14 January 2011

## Project Star - Transport Strategy to respond to comments to MUEF Section 75 Submission

Figure 8: Swept Paths for a 12m Bus/Truck

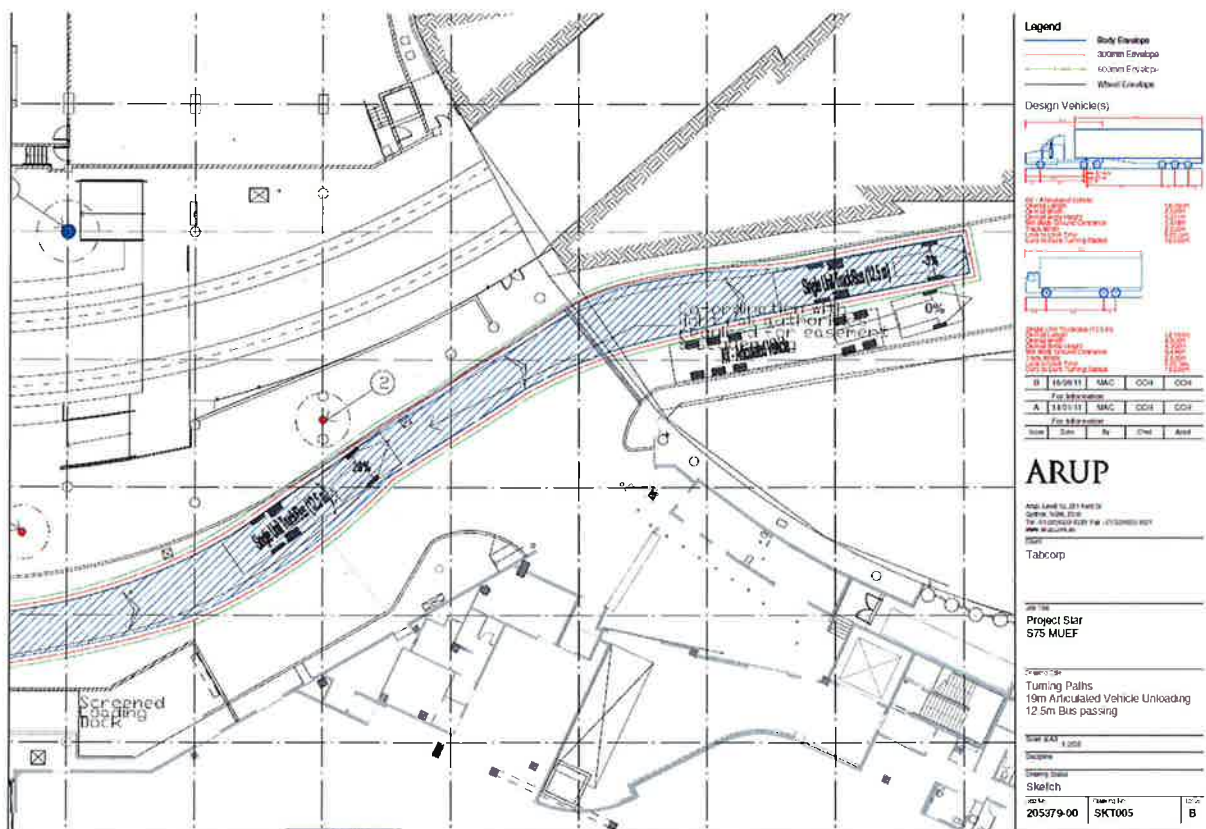
- The plans submitted for the modification do not show adequate details of the proposed loading areas and compliance of these areas with AS 2890.2 – 2002 for heavy vehicles or AUSTROADS requirements for vehicle swept paths. Request plans demonstrating compliance be submitted to the Department of Planning.
- The layout of all vehicle accessible areas to be in accordance with AS 2890.1 – 2004 and AS 2890.2 – 2002 for heavy vehicles.
- All vehicles to enter and leave the site in a forward direction.
- All works are to be at no cost to the RTA.

- The traffic report submitted states that the existing loading dock will be sufficient for the proposed (more intense) use, but there is little information to demonstrate that this is the case. More information requested for expected servicing of the new facility having regard to the events, equipment and trucks to be catered for.

The MUEF will use the existing Loading Dock located within the Casino building off Pirrama Road. This Loading Dock operates 24/7 and currently serves the Sports Theatre. From discussions with Tabcorp, it is estimated that there will be 20-30 concerts per year, with 6-8 trucks per concert. With an average loading time of 30mins to 60mins, all trucks would be unloaded/loaded within 3-8 hours. Trucks would enter the site via the bus interchange, which is one way and exit on Pirrama Road north of Jones Bay Road.

The loading dock is designed for one truck at a time, with no provision for an additional holding area on site. Truck arrivals would be managed and staggered so that arrivals only occur when the dock is free. This would ensure that the bus interchange and surrounding roads are not affected by the loading dock truck movements. The largest truck, with a 13.7m container, would park to the right of the internal bus carriageway, and smaller rigid trucks would be able to reverse into the loading area. The attached plan, SKT005 shows the parked truck at the location of unloading. As shown, this position allows a bus to pass the stationary truck, although loading and unloading would occur at off-peak times to reduce the number of occurrences. This design complies with AS 2890.1 and 2890.2.
